RE: File Nos.: CAO15-001 and SEP15-001
5637 East Mercer Way
Mercer Island, WA 98040
SEPA Determination of Non-Significance

Applicant: Bill Summers of MI Treehouse, LLC

I'm writing to oppose the City of Mercer Island's approval of a SEPA Determination of Non-Significance for the above referenced property.

**PROPOSED RESIDENCE SECTION**

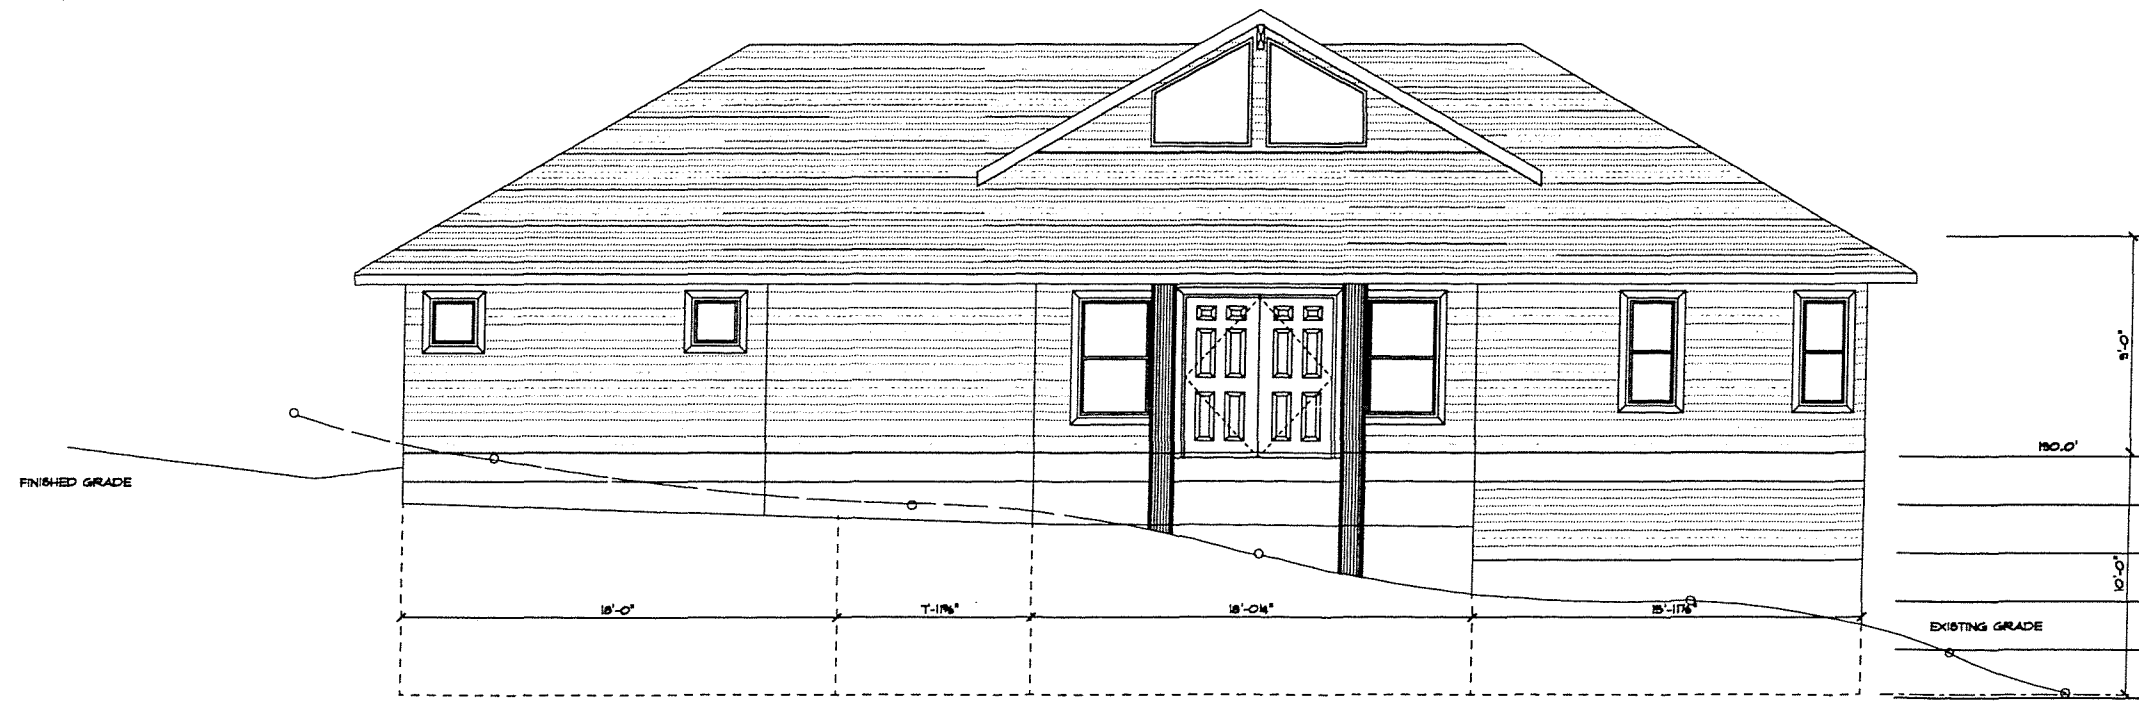
- 1) The Geotechnical and Wetlands reports referenced above note that the home will be constructed on pin piles so, “The residence could be built essentially at-grade or on an above-grade pile-supported deck,” and “The site plan utilizes pin piles, which are not considered wetland fill, to minimize actual wetland impact.” However the site plan shows the foundation walls of the home imbedded up to 8 feet into the sloped terrain (wetland) with a concrete foundation slab on top of the pin piles. This is not exactly “at or above grade” and not minimal intrusion into the functioning wetland.

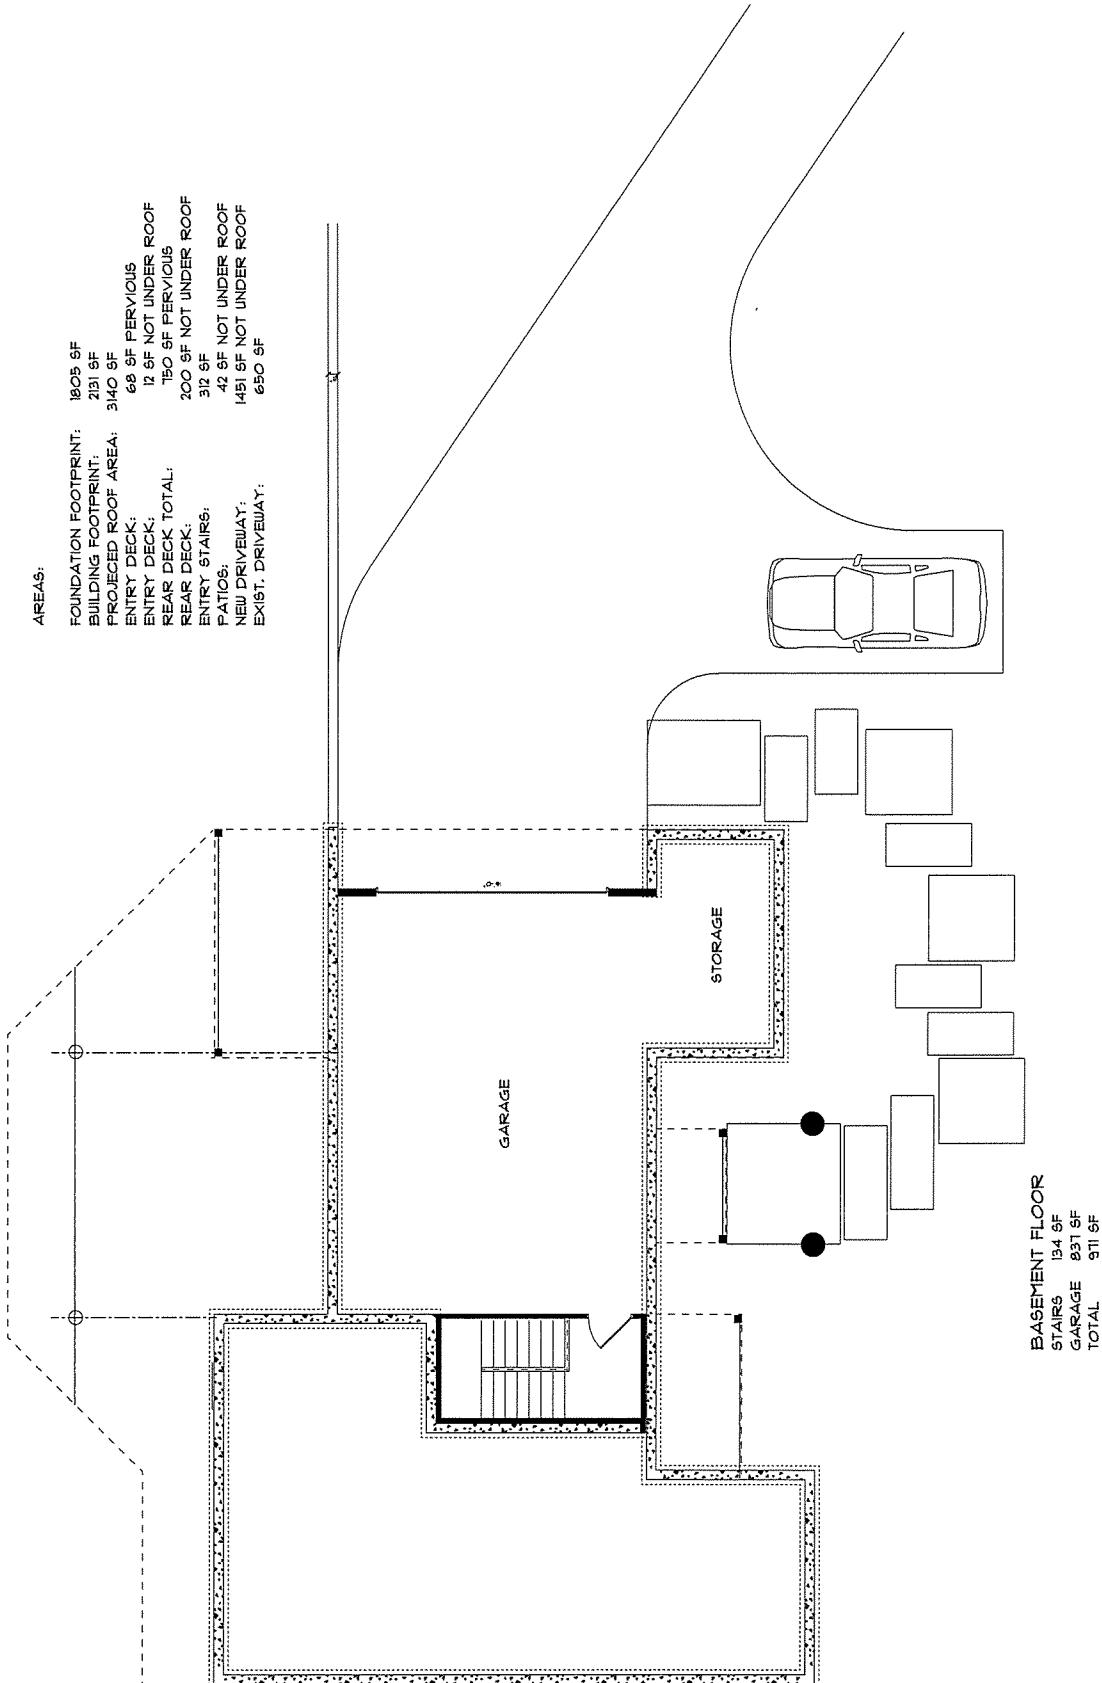
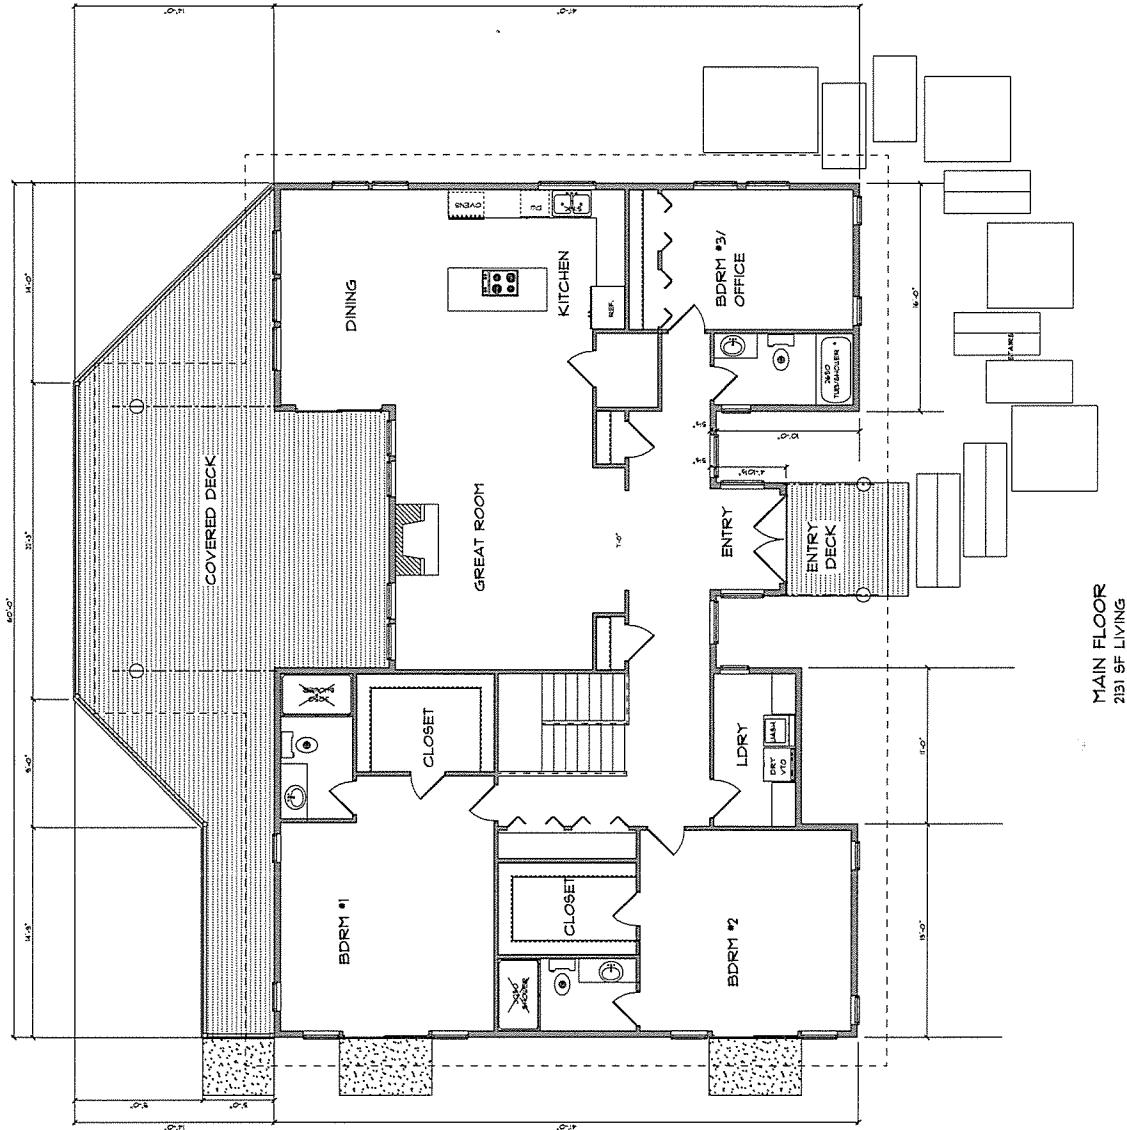
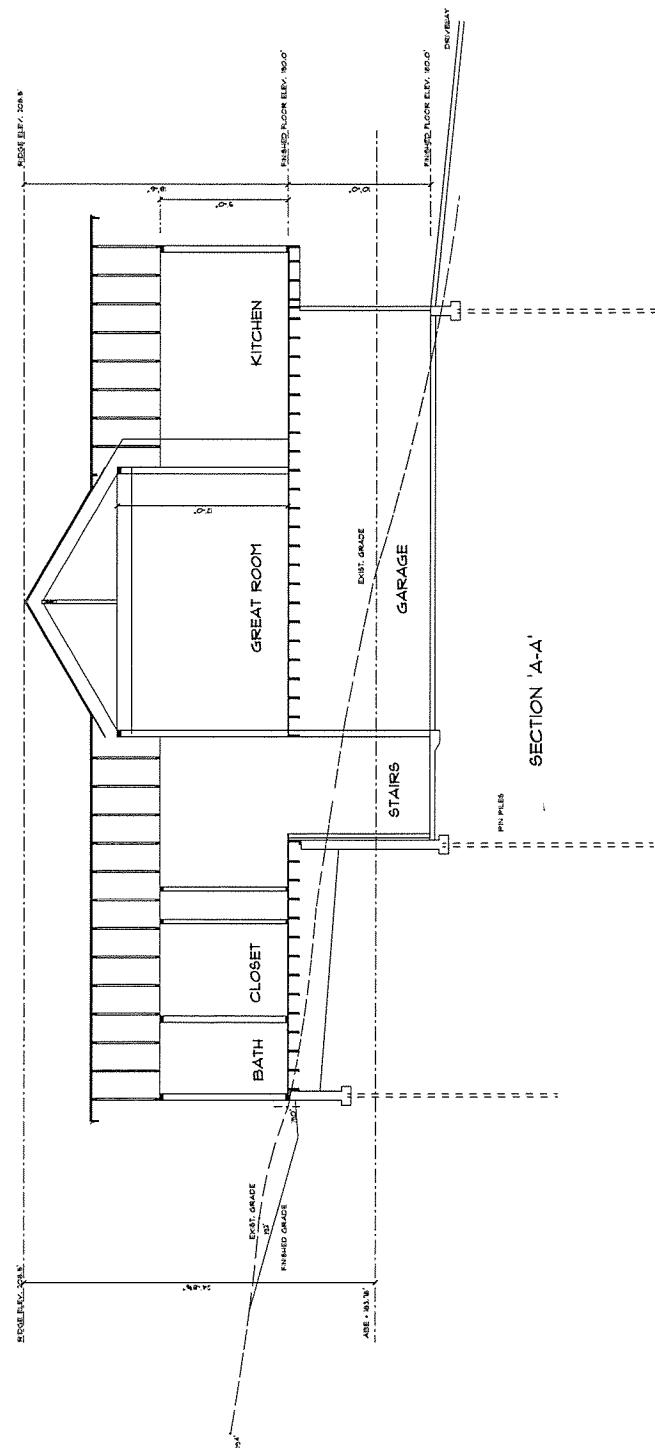
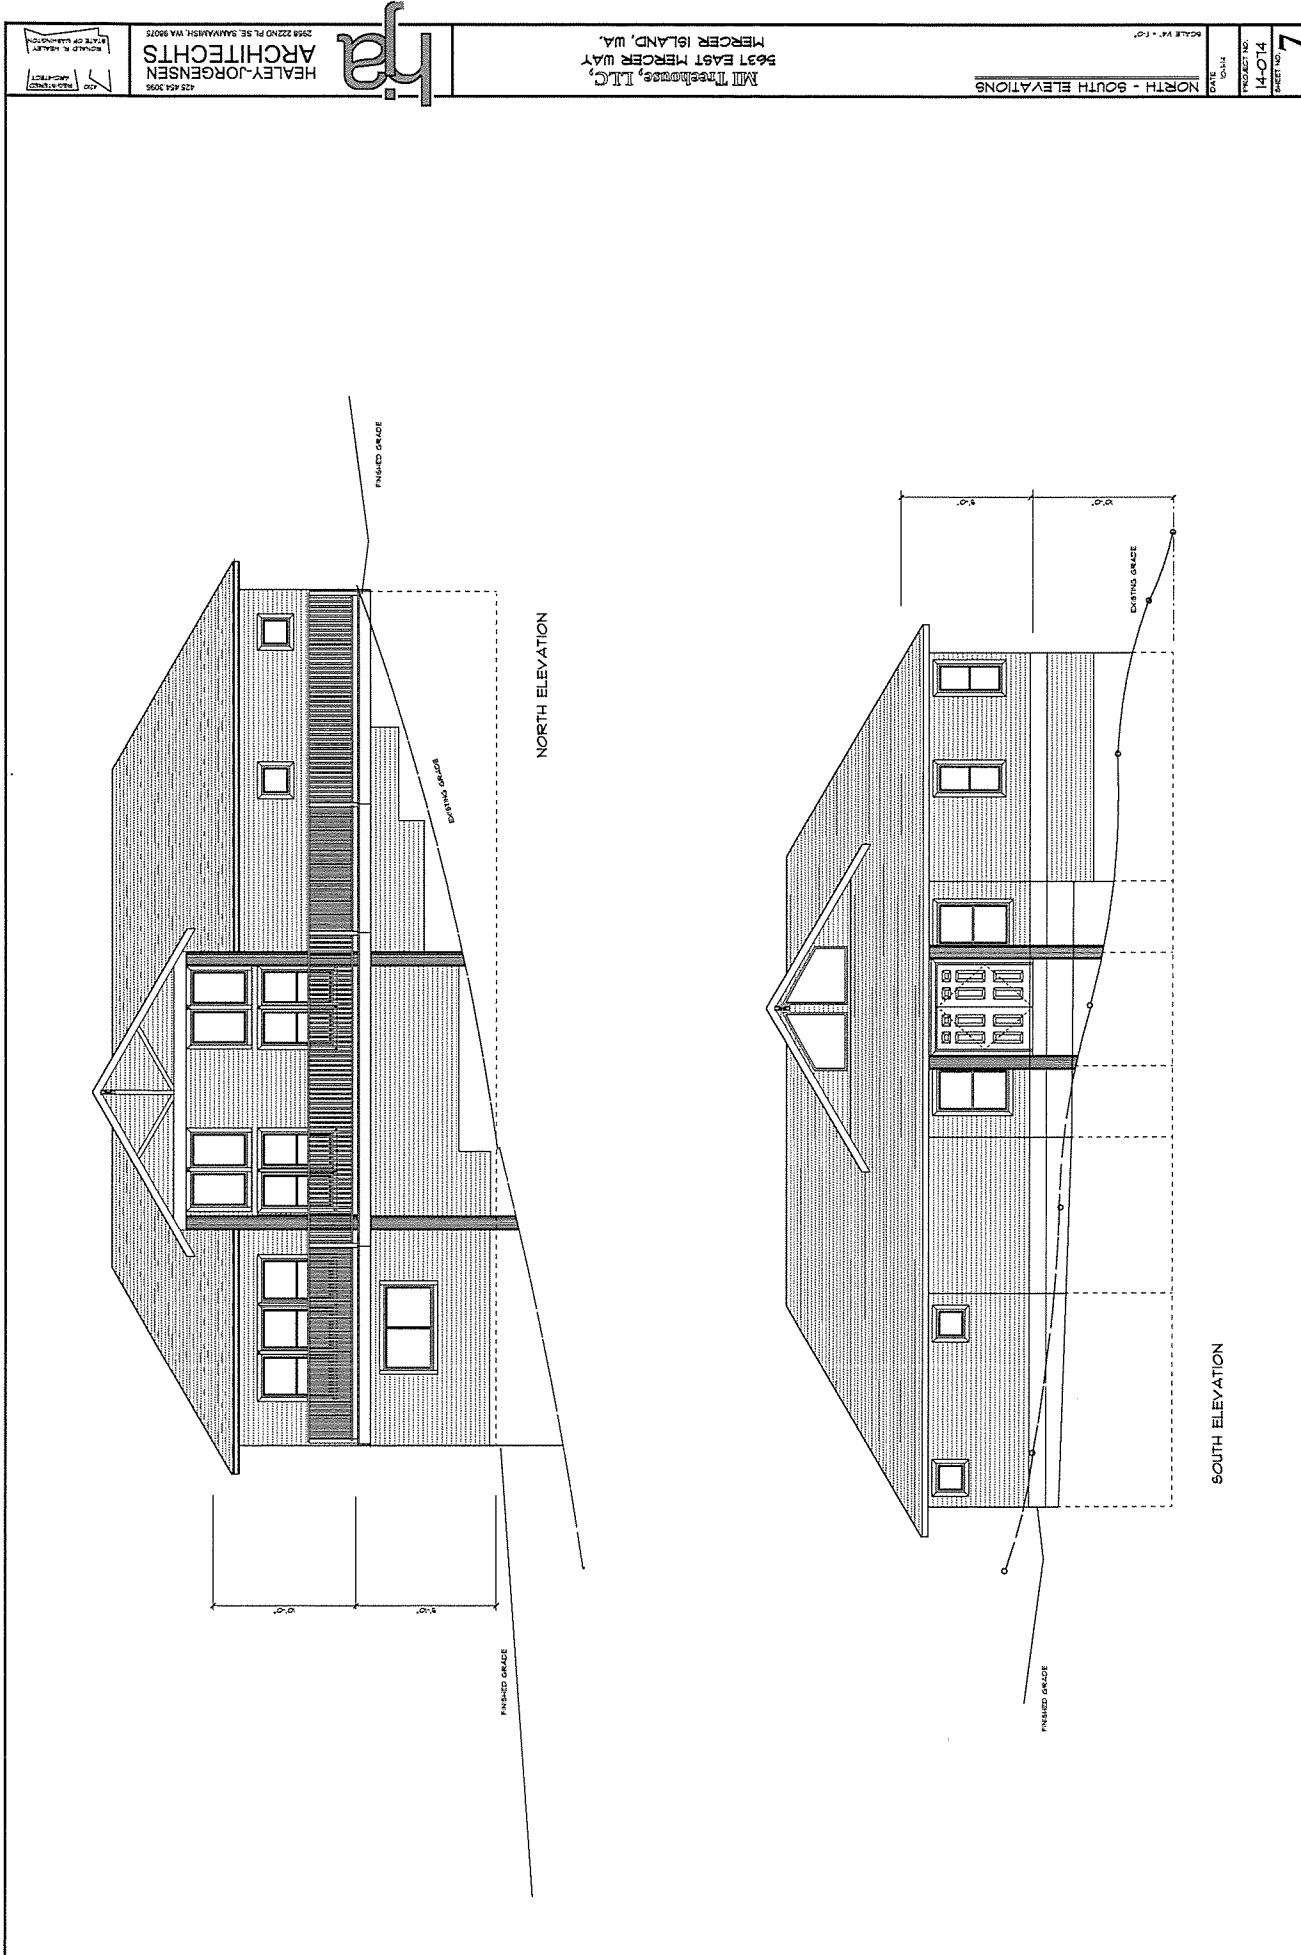
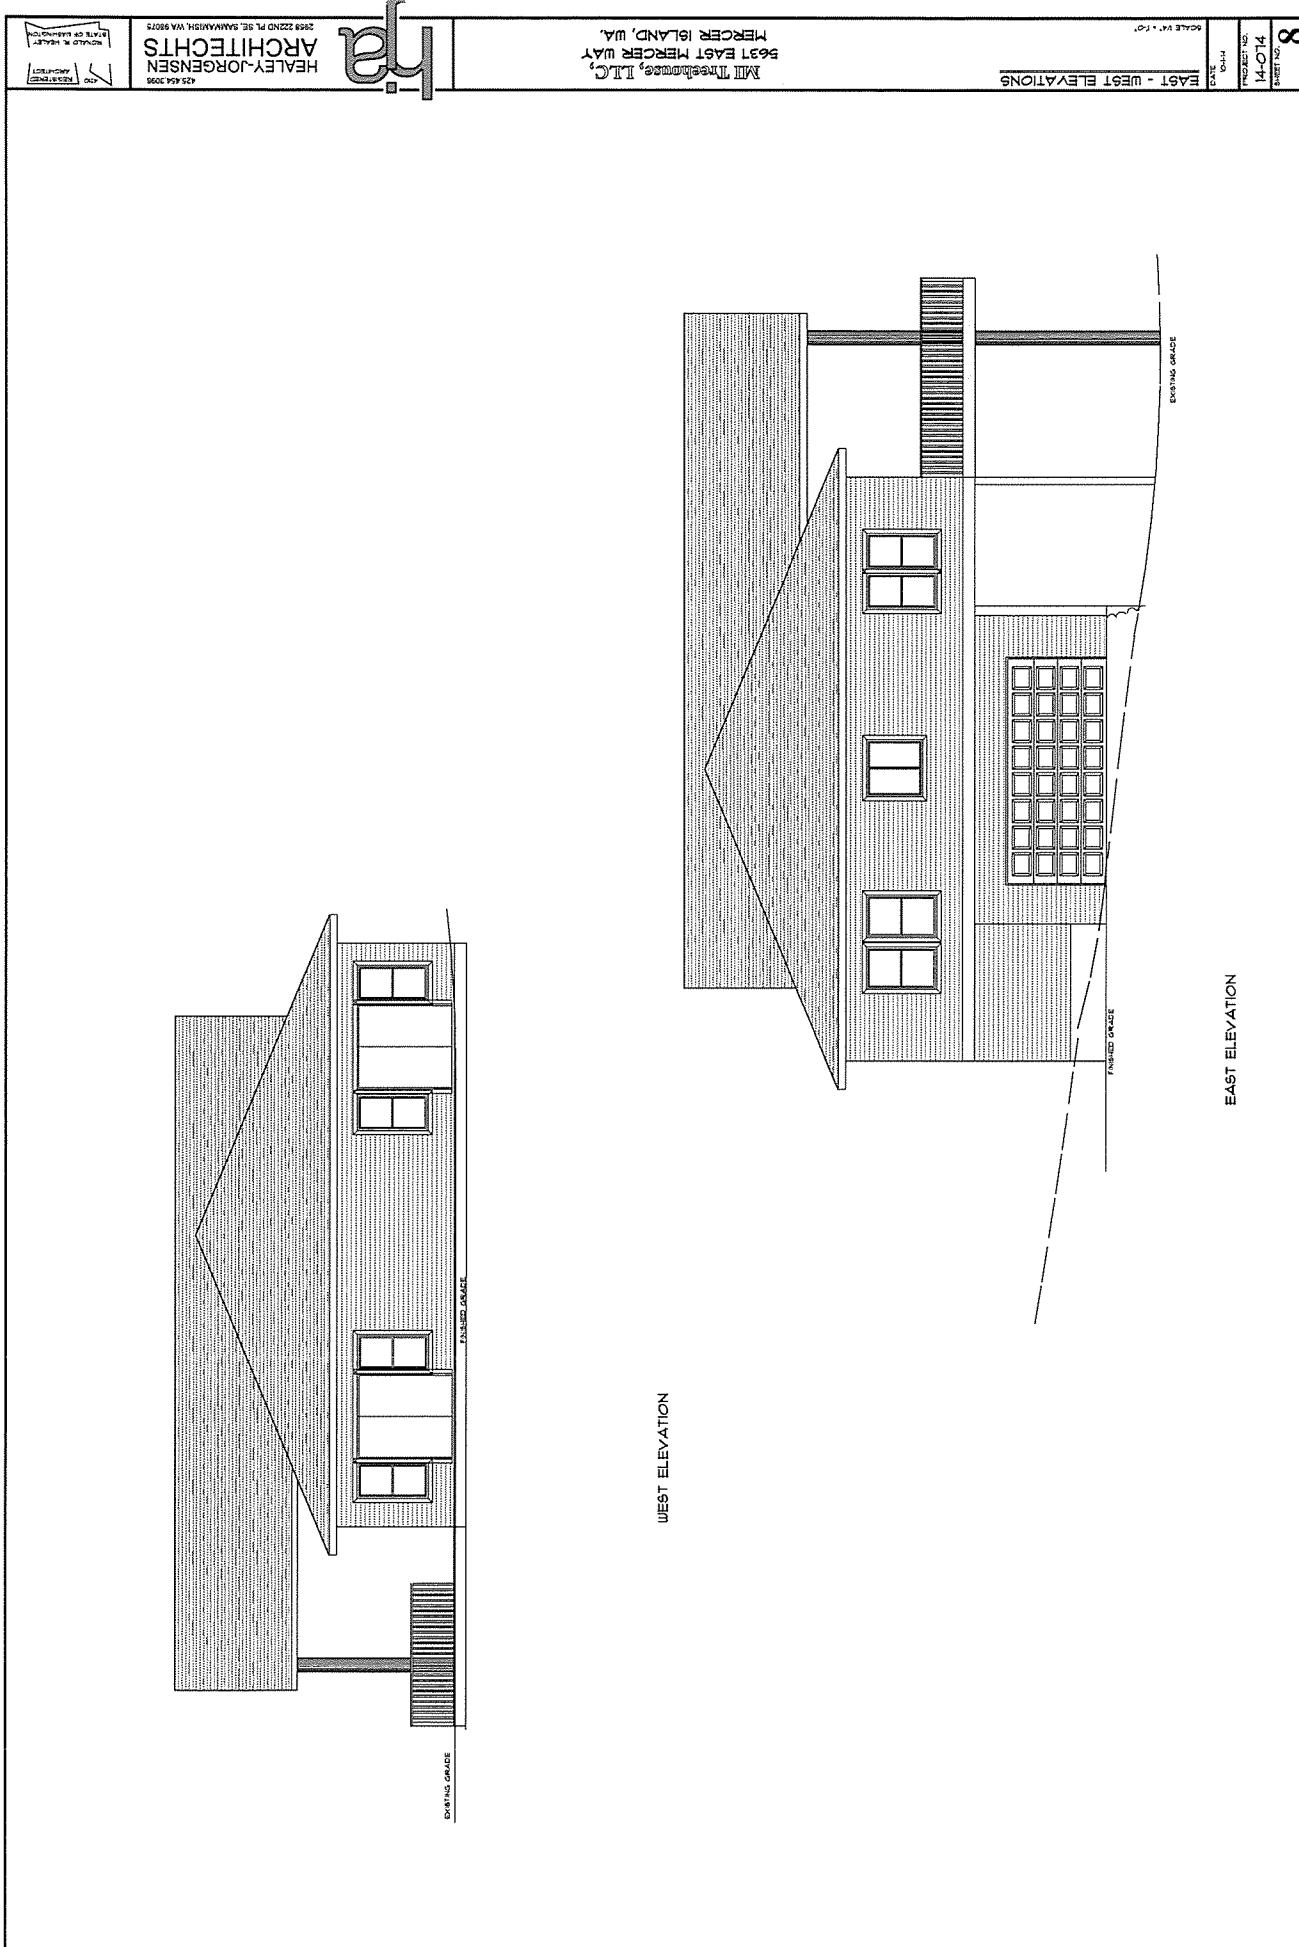
- 2) The site plan shows the entire proposed residence surrounded by a siltation fence with a retaining wall that appears to be stacked boulders similar to the wall that lines the uphill driveway at 5645 East Mercer Way. There are no construction specifications on this wall, but it is clear that the wall and the residence foundation walls are cut into the toe of the south-side steep slope. Any excavation of the toe of the steep slope increases the risk of undermining the stability of the steep slope. This is a safety and welfare hazard to the residents on top of the steep slope and to the residents of the proposed home.

- 3) Given that the entire development site is a wetland with 20 feet a saturated soil, will the residents of the proposed home be prohibited from using the yard area surrounding the house? That seems unreasonable but it is a wetland and residents tend to build gardens, patios, play areas, etc. and this activity further encroaches on the wetland and decreases its function. Therefore the wetland impact area is far more than the proposed 2,200 square foot footprint of the house or the 3140 square foot roof area.

- 4) The impervious surface area coverage is stated as 2200 square feet however this does not include the driveway and sidewalks. What is the total impervious surface coverage being proposed on this site?

- 5) The house foundation, deck, backyard area, driveway, and retaining wall with siltation fence on north-side of the driveway are all inside the 50 foot buffer from the Type 2 Watercourse which is not permitted under MICC 19.07.070.
